**Re: Byron Shire Council submission - Cultural Events Site - State significant Development Application (SSD 8169)**

Two concurrent applications are with the Department of Planning and Environment (DPE) for the North Byron Parklands (Parklands) Site.

Drawn:	Reviewed:	Approved:	Date:	Scale: 1:2,000 Approx @ A3	
HM	SD	SD	7/12/17	Job No: 1912	Sheet: 1 of 1
All units in m unless otherwise specified				Drawing No: Figure 8	Revision No: 2

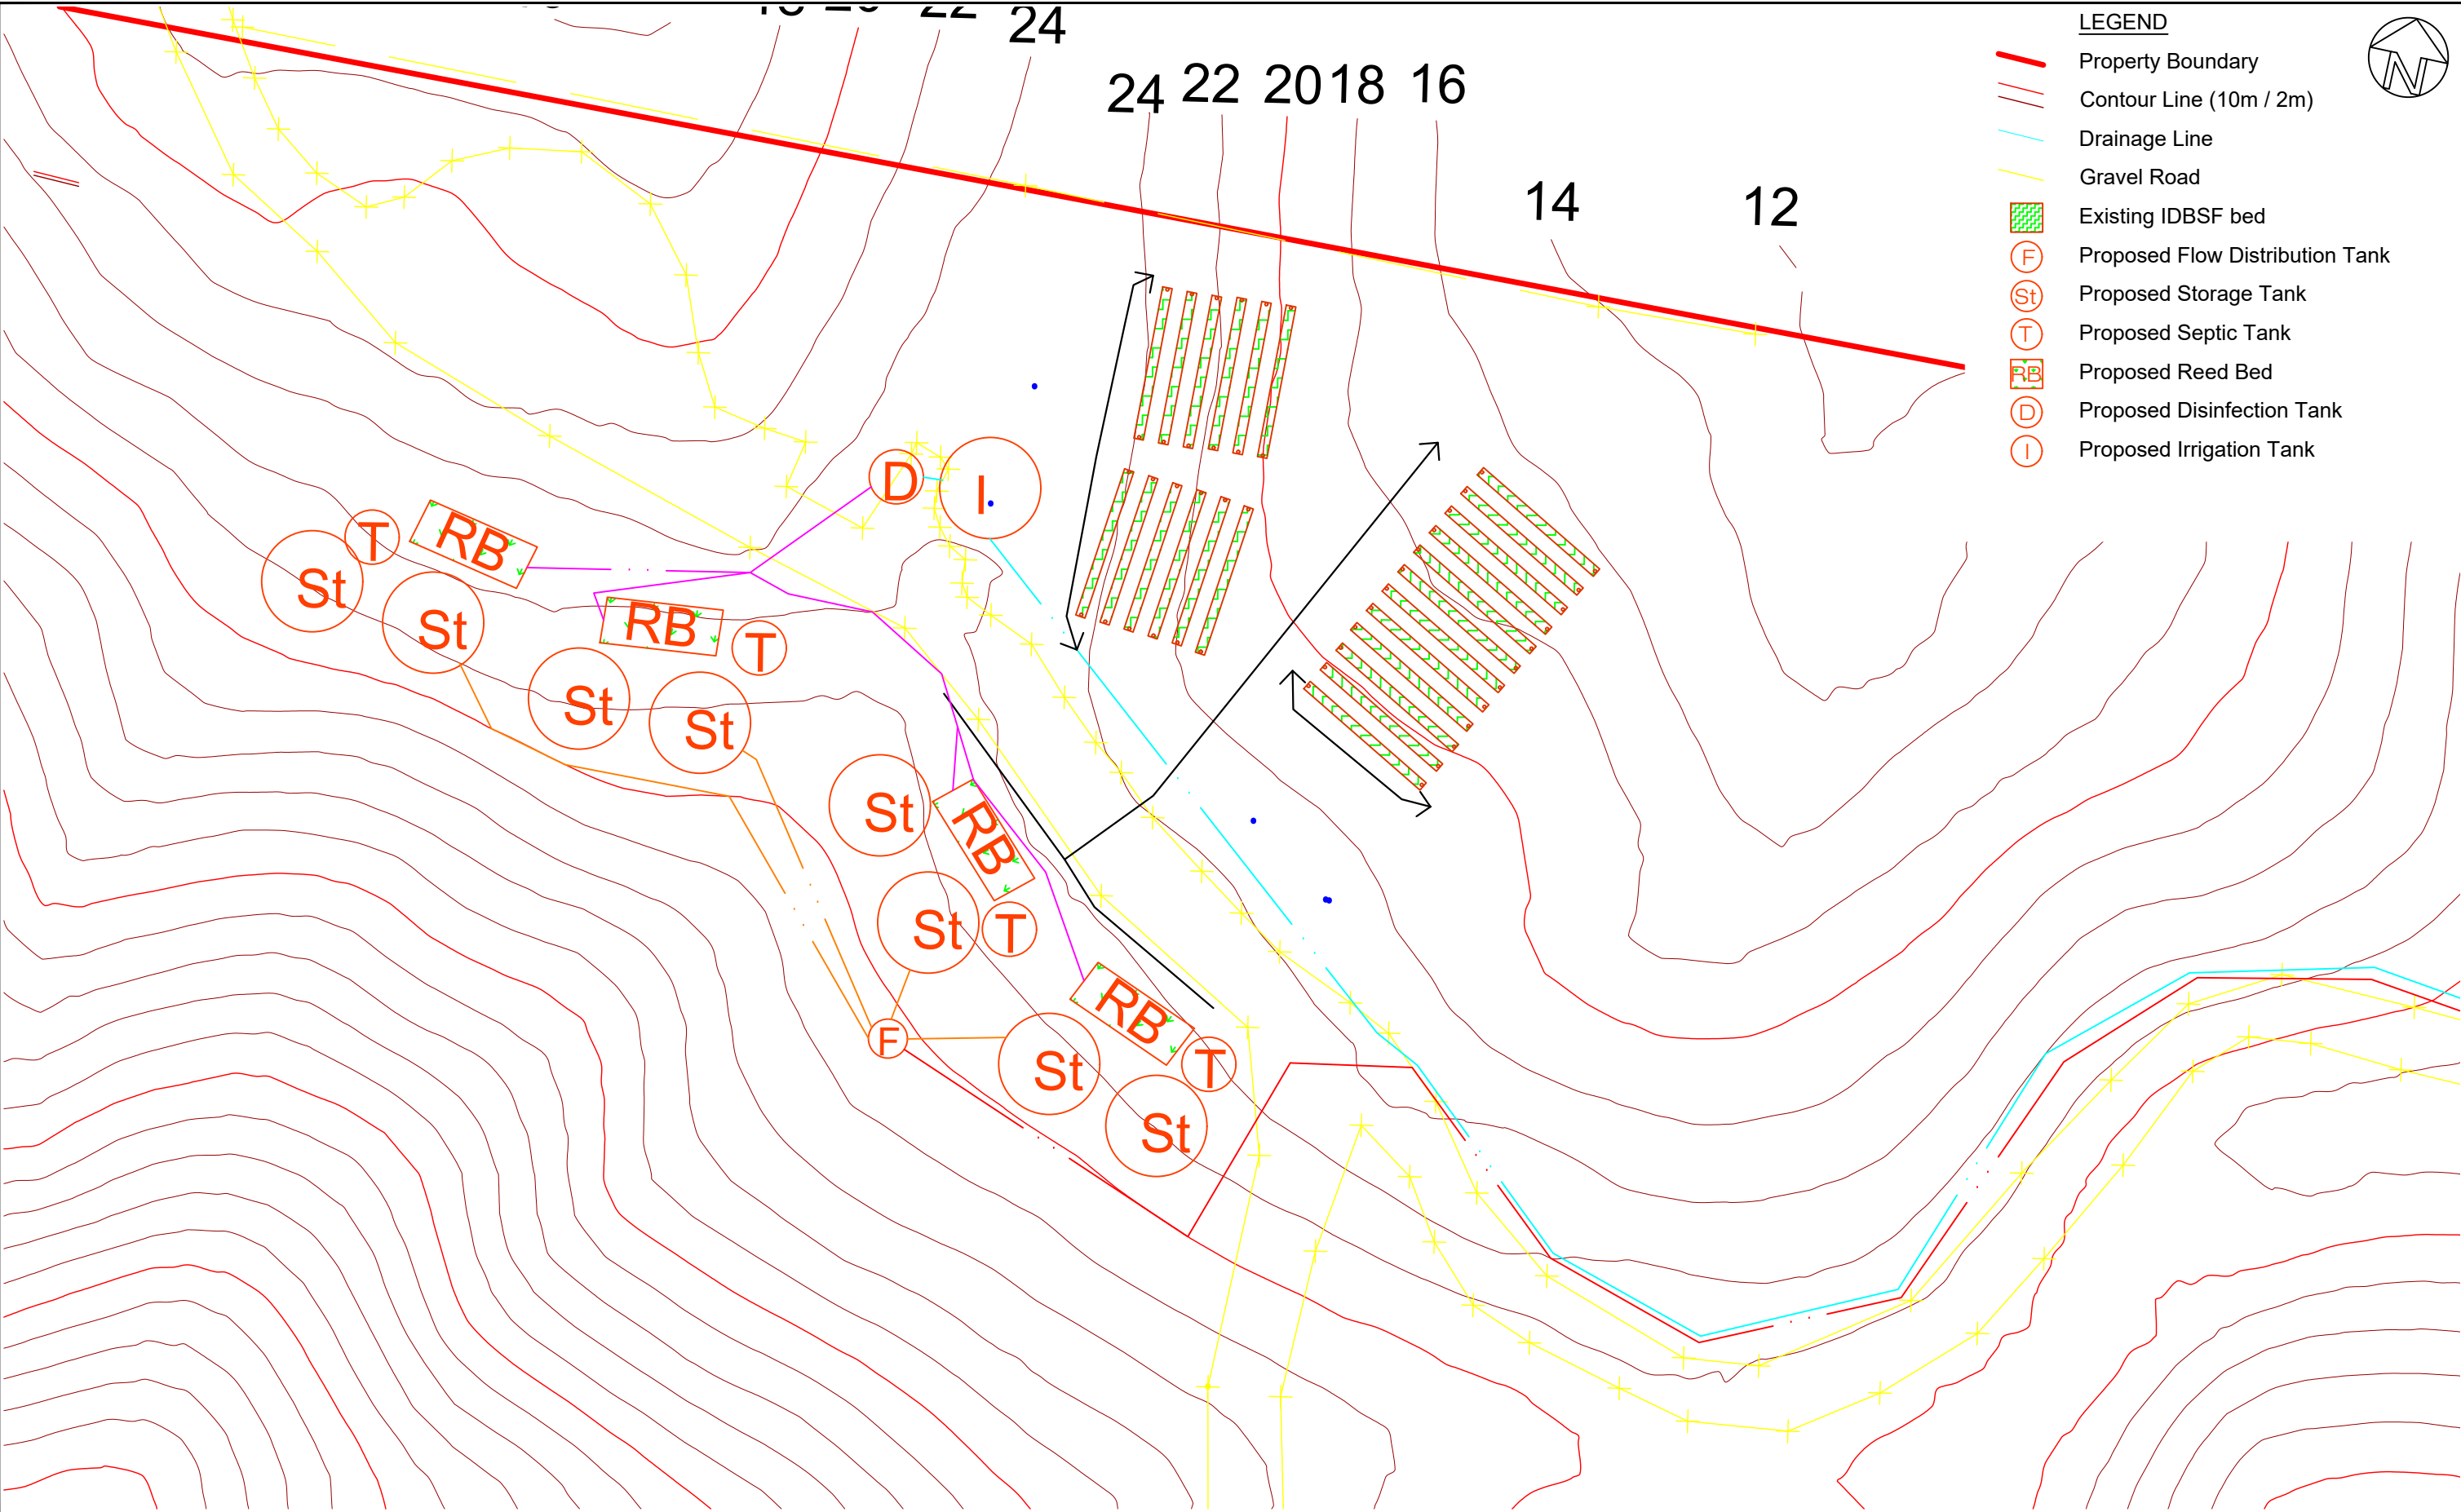
A review of the Tweed Byron Flood model has identified that the site of EMA 2 is located below the 1:5; 1:20 and 1:100 flood level. The use of flood prone area for effluent dispersal/ disposal is not acceptable, having regards to the potential impacts of receiving waters within both the northern end of the Brunswick River Catchment and the southern end of the Crabbes Creek/ Mooball Creek Catchment which flows northwards into Tweed Shire.

The application of treated effluent on EMA 2 (the proposed new Land Application Area on flood prone land) requires treatment in the form of lime and gypsum to improve ability to accept effluent. Details will need to be submitted by the applicant should this be supported in a limited way to enable its use for treatment dispersal/ disposal.
